Our Ref: EP/70/12/

9th August 2012

Alterations & first floor extension, providing a reduced garden room on the ground floor, together with conversion of garage to a gym & 2 new bedrooms, study & bathroom to first floor. Removal of existing pitched roof & replace with lower mono pitched roof
Sandgate House South Strand East Preston Littlehampton

1207 SK26
 Sandgate House, East Preston
 Elevations As Proposed - sheet 2
 June 2012
 scale: 1:100

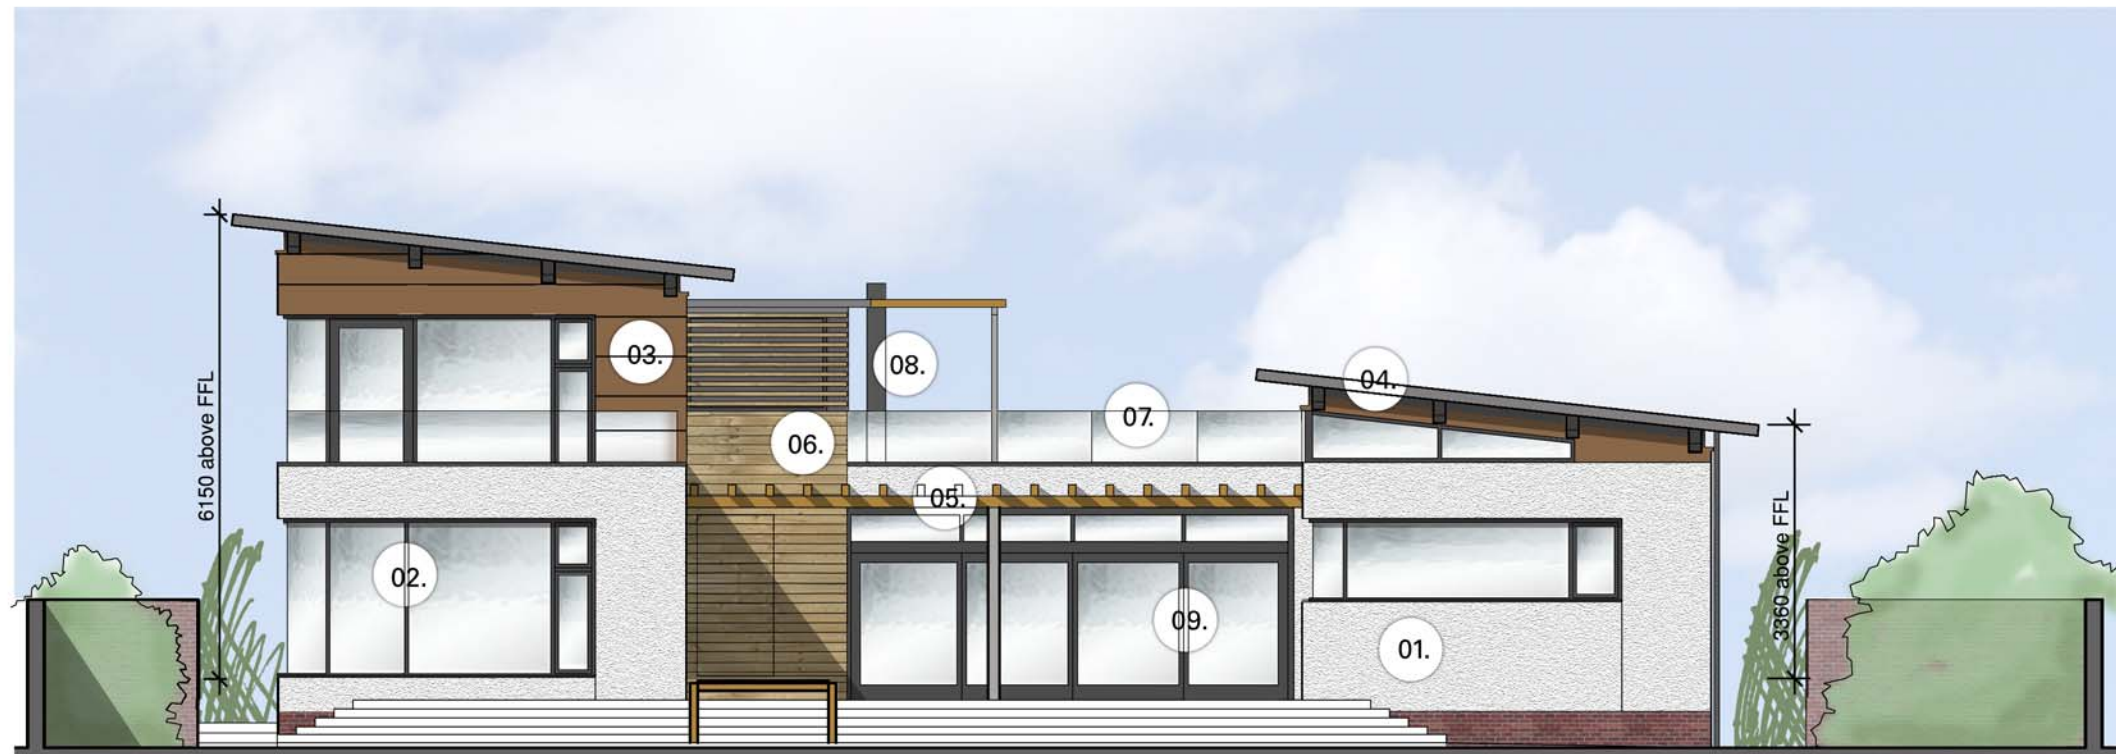
Further to our letter dated the 24th July, we also note that the Council recently turned down EP/62/12 (planning application for a different property, just along the beach). EP/70/12 is more controversial in its application in adding a whole floor at beach front aspect. This would also not respect the scale and appearance of the existing property and will have a detrimental impact on the wider locality, changing the character and appearance. We would urge the Council to therefore take a consistent approach.
